Strategic Drainage Consultation

Consultation on Application Number: 2013/90249

Address: Lock Street, Thornhill, Dewsbury, WF12 9BZ

Proposal: Outline application for erection of 106 dwellings, demolition of existing buildings and railway embankment.

PROPOSED SITE PLAN

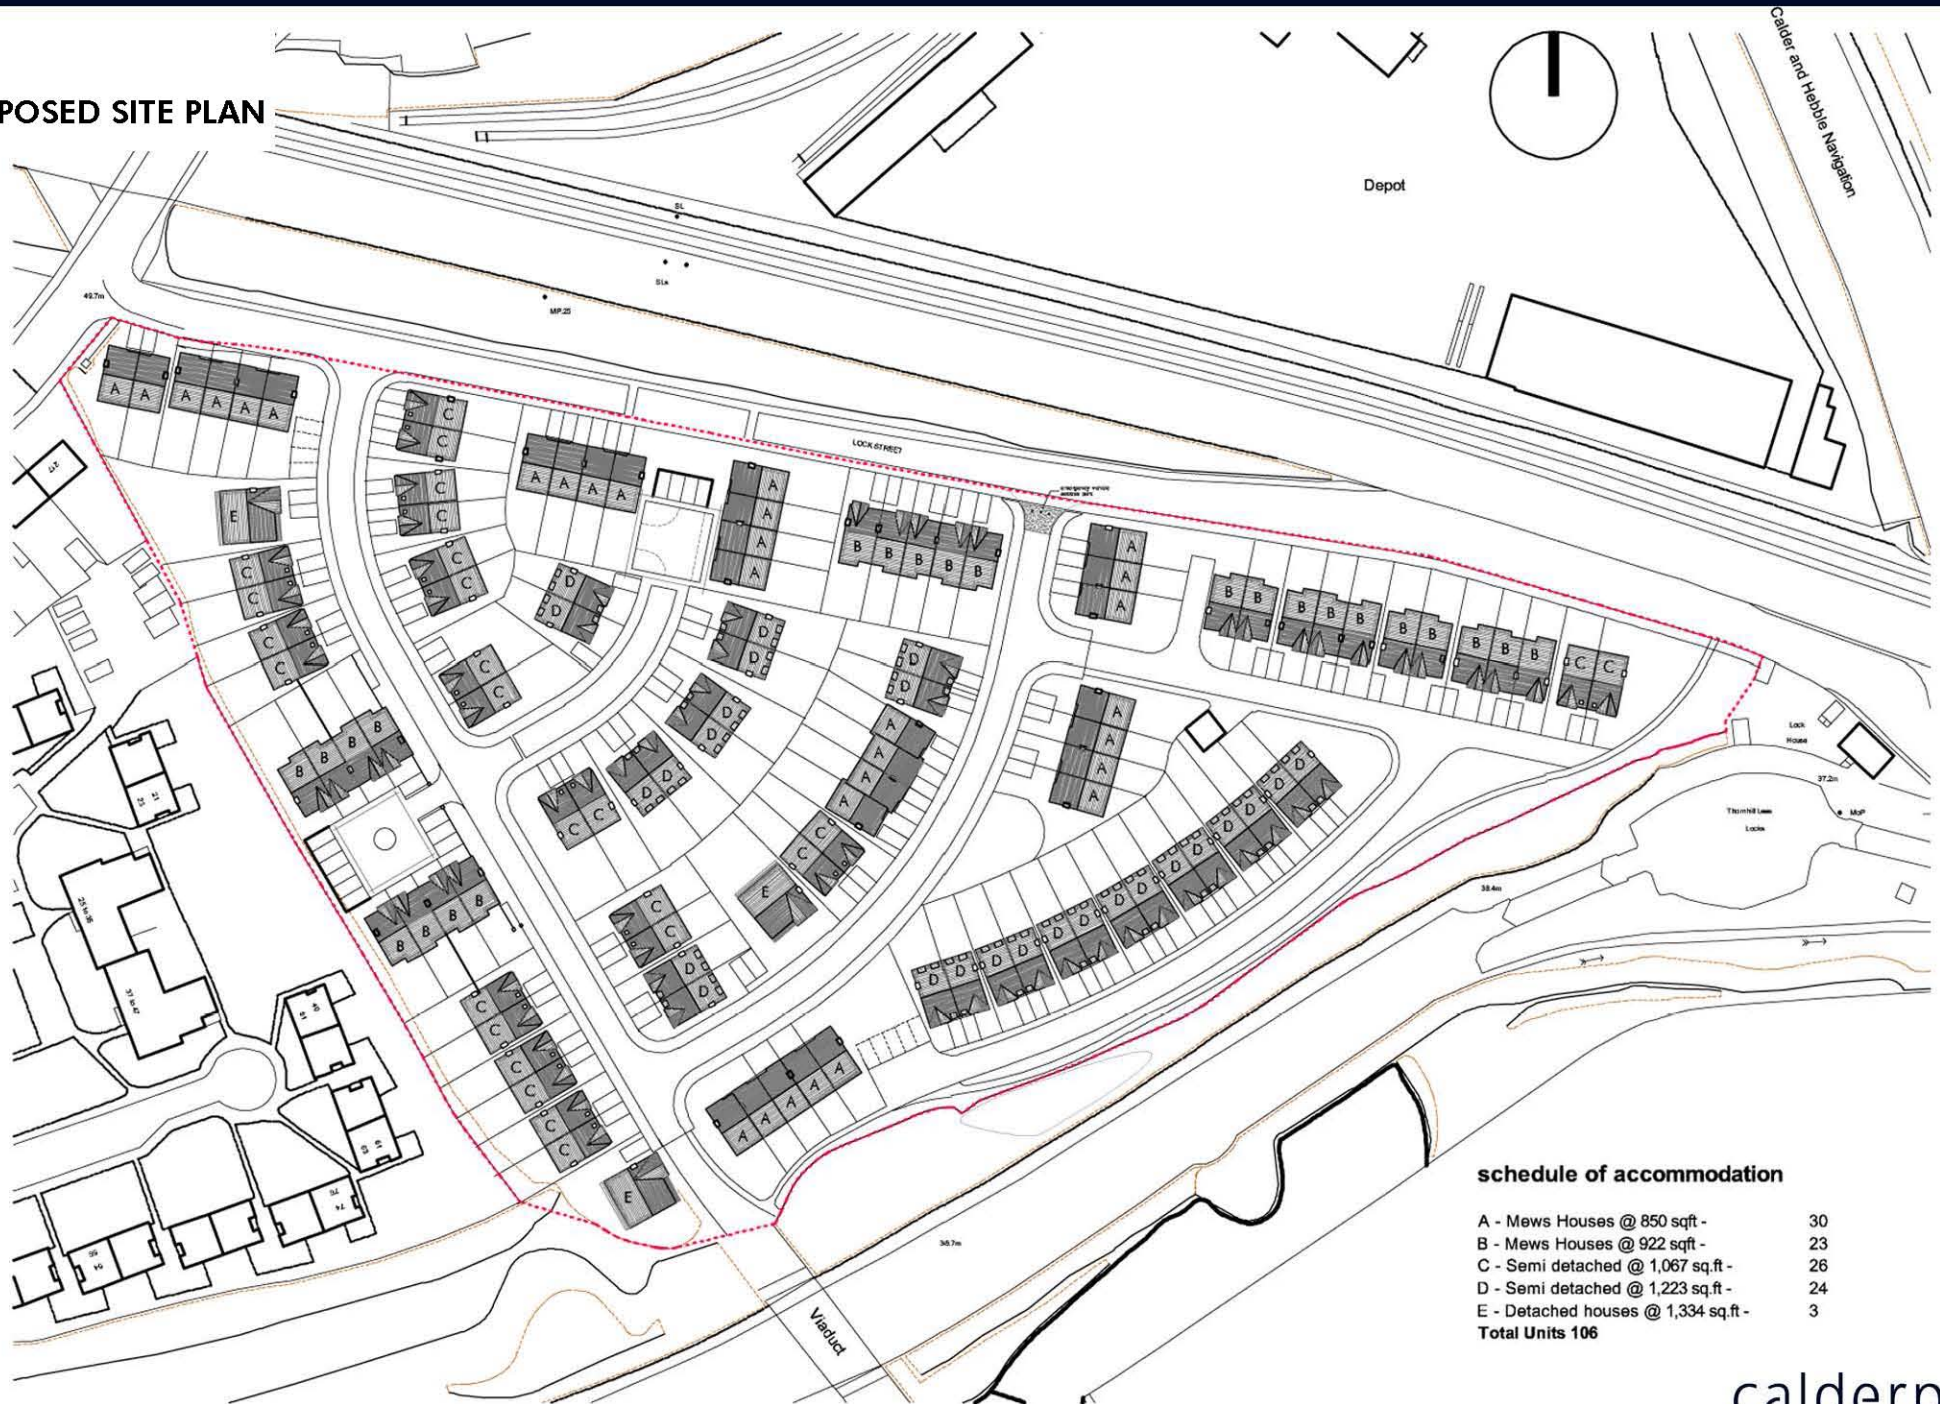
The flood risk assessment mentions the use of swales and ponds for storage but no space appears to have been made in the layout plans for such techniques.
